DRB Application No.: 08DRB-70442 Project # 1007522  
 Project Name: EAGLE ROCK ESTATES UNIT 4  
 Agent: SHAKEEL RIZVI Phone No.: 315-6563

**DRB CASE NO/PROJECT NO: 1007522**

SUBJECT: Project # 1007522, 08DRB-70442 Vacation of Temporary Public Easement,  
08DRB-70444 Minor – Preliminary /Final Plat Approval, Lots 1-3, Block 2,  
Eagle Rock Estates Unit 4, Located on the Northwest Corner of Eagle Rock Ave.  
NE and Obsidian St. NE.

Drawn By:	ECM/JPA	Date:	09-30-05
Checked By:	TA	Drawing Name:	02089B4-PLT2.DWG
Job No.:	02-089	Sheet:	2 of 2

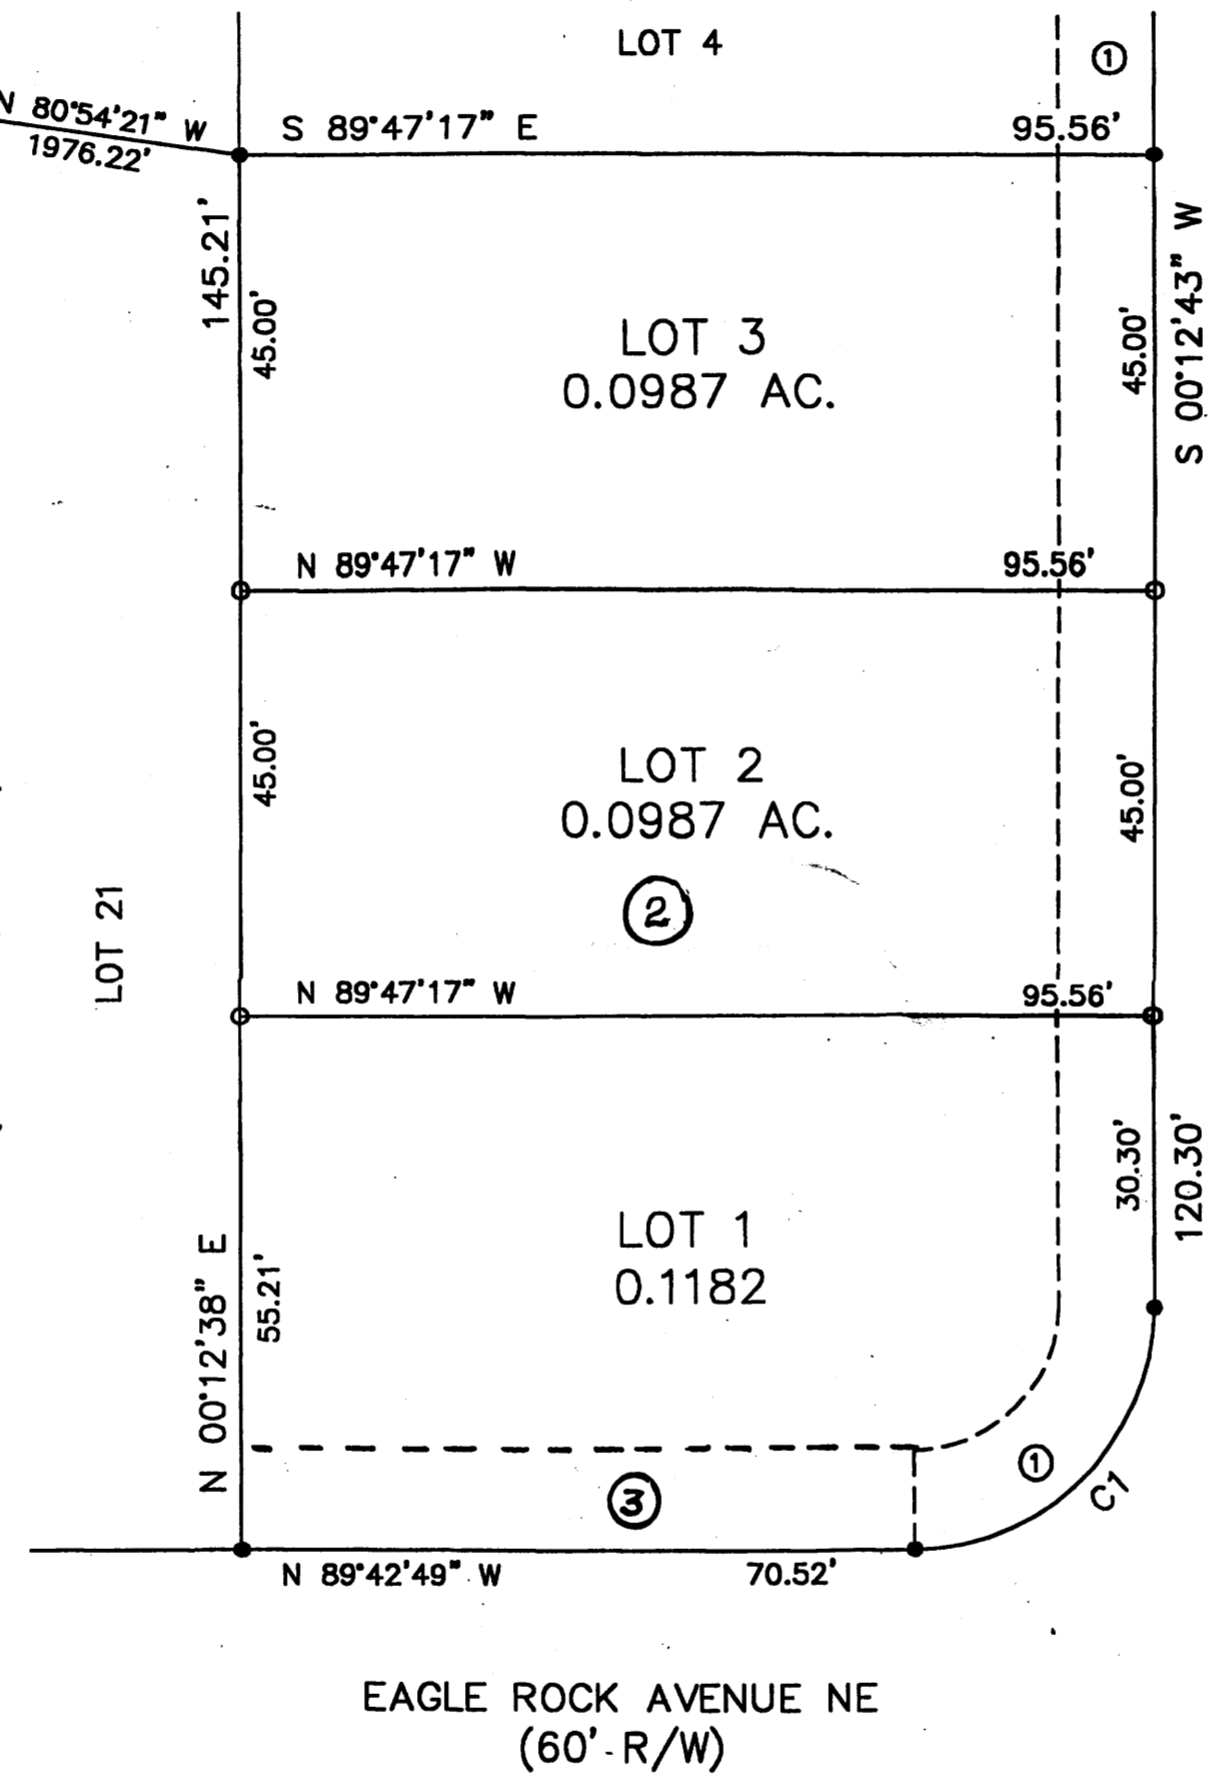
Plat needs to define the existing easement to be vacated; add a note “to be vacated with this plat.”

Refer to comments from Hydrology/ City Engineer regarding proposed vacation.  
Please remove Zoning Note (#8) from plat. Please provide a note consistent with Section 14-14-4-7 of the Subdivision Ordinance which is specific to this type of request, i.e. use the words "THIS PLAT" (rather than the words "REQUESTED FINAL ACTION") at the beginning of the note, and do not use the words "OR SITE DEVELOPMENT PLAN FOR SUBDIVISION" at the end of the note.
